Planning and Urban Development Department

To: Stuart O'Brien, Chair and Members of the Portland Planning Board
From: Nell Donaldson, Development Review Services Manager
Date: May 15, 2015
Re: Bishop Street Apartments, 72-78 Bishop Street, Avesta 72 Bishop Street, LP
Project #: 2015-060 **CBL:** 293 C002001
Meeting Date: May 19, 2015

4 BITUMINOUS SIDEWALK WITH GRANITE CURB- CITY OF PORTLAND  
L5 NOT TO SCALE

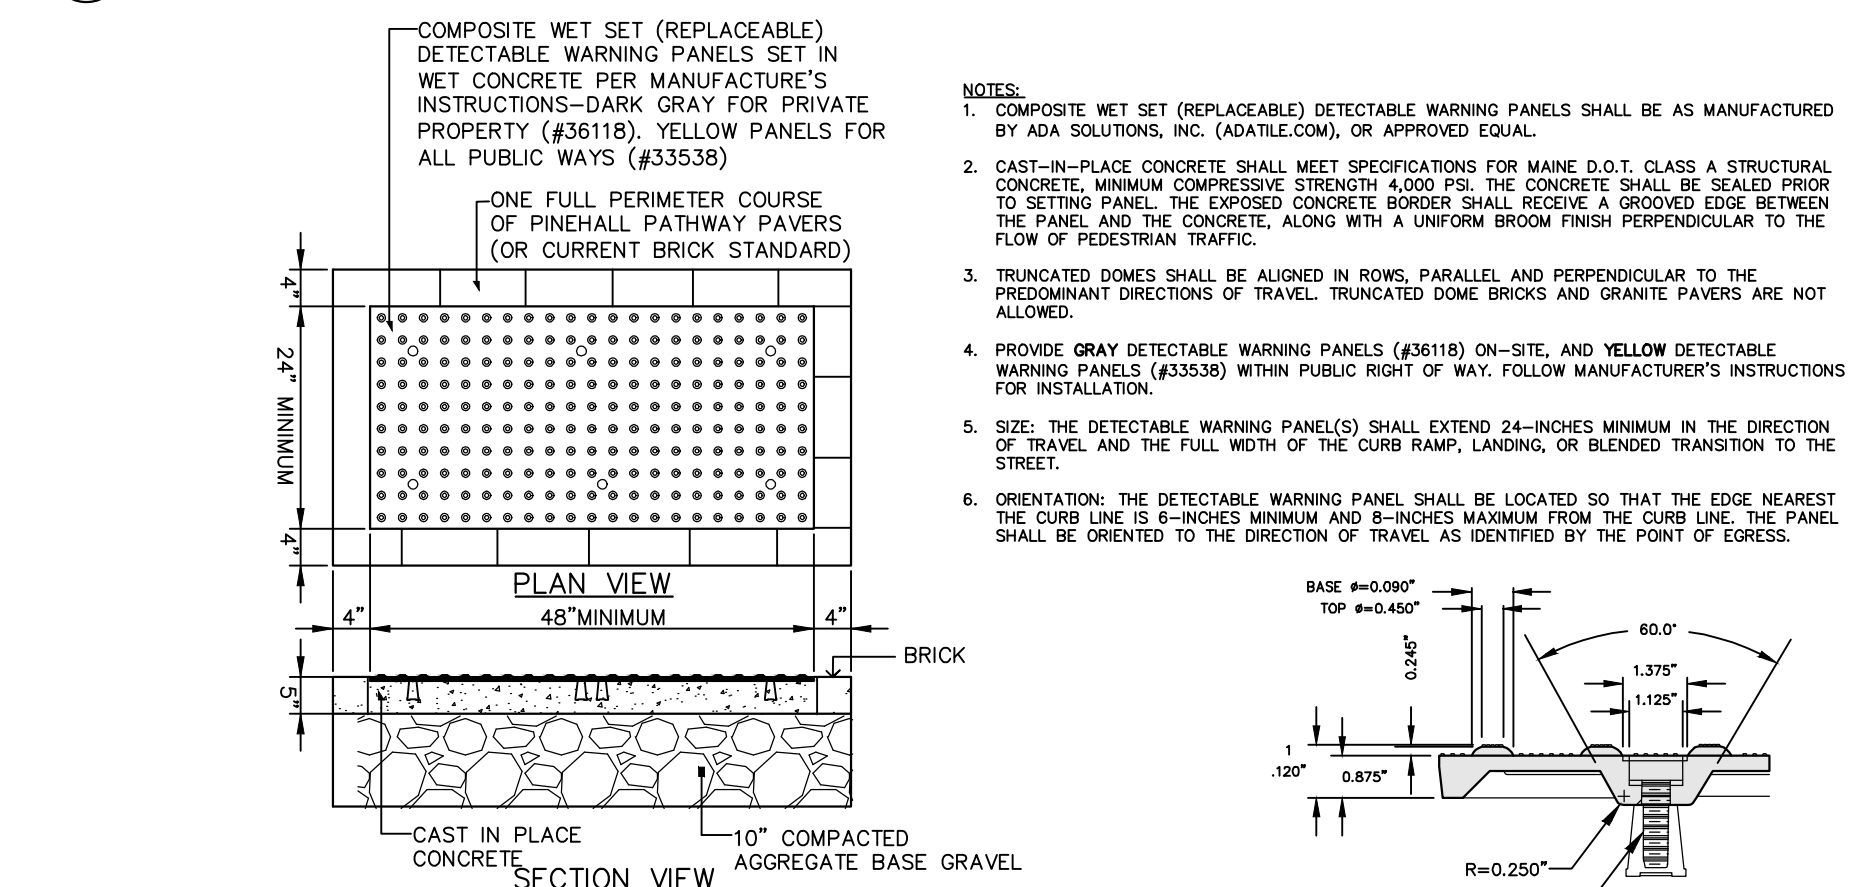
The Bituminous Sidewalk with Granite Curb – City of Portland detail on Sheet L5 should be modified to comply with the City of Portland Technical Manual.

**1 SIDEWALK EXTENSION**  
 SCALE: 1"=10'

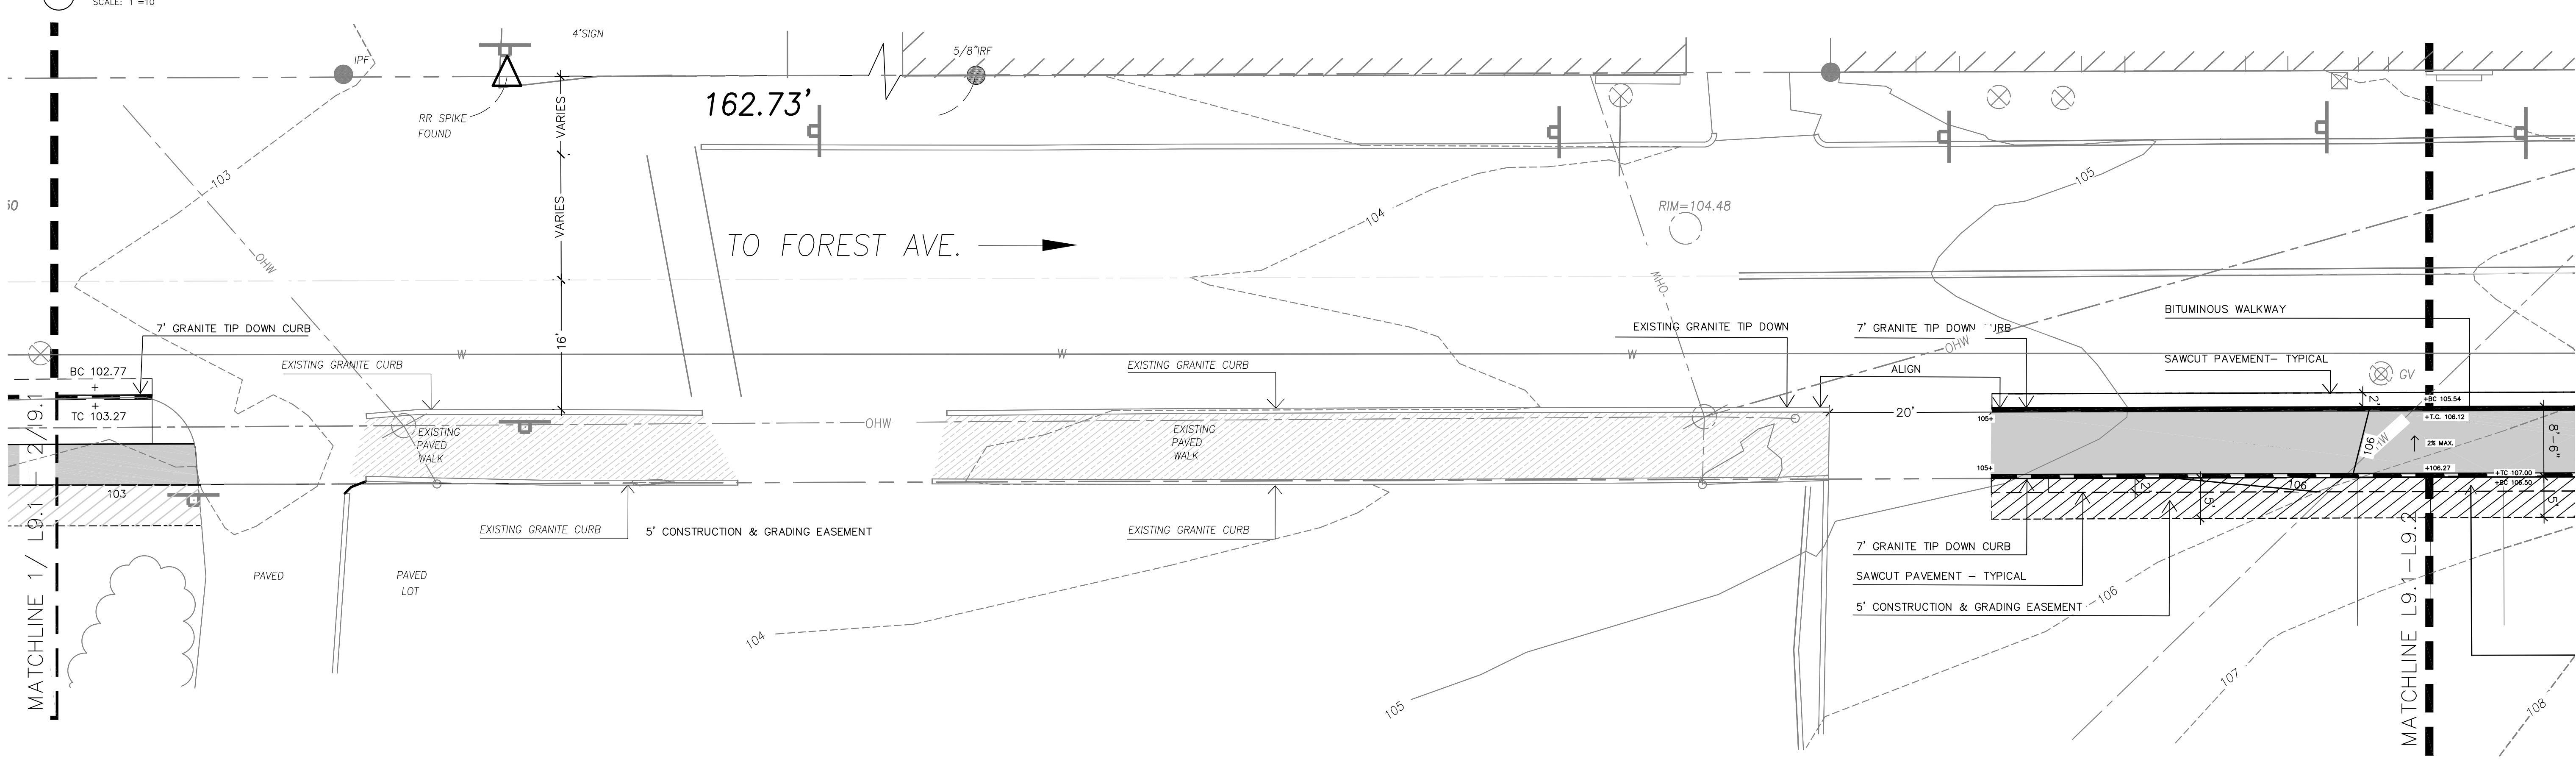
The preliminary plans show the sidewalk, with a grassed esplanade, extending east from the site, past Mayfield Street, to the location of an existing sidewalk segment at 12 Bishop Street. However, the current plans do not show a proposed sidewalk connection to the east of the 12 Bishop Street property and all the way to the Stevens Avenue/Forest Avenue intersection at Morrill's Corner. This outstanding section abuts only one property owner but would replace what now constitutes a single, large curb cut.

The applicant has agreed to extend a sidewalk to Forest Avenue. The plans show the sidewalk terminating at the parking lot prior to Forest Ave. It is desirable to have the sidewalk continued through this parking area to Forest Ave. Drive cut location(s) will need to[be] determine[d] with the parking lot owner.

The Applicant should provide details for proposed sidewalk ramps in accordance with the City of Portland Technical Manual for the Bishop Street Sidewalk Improvements.
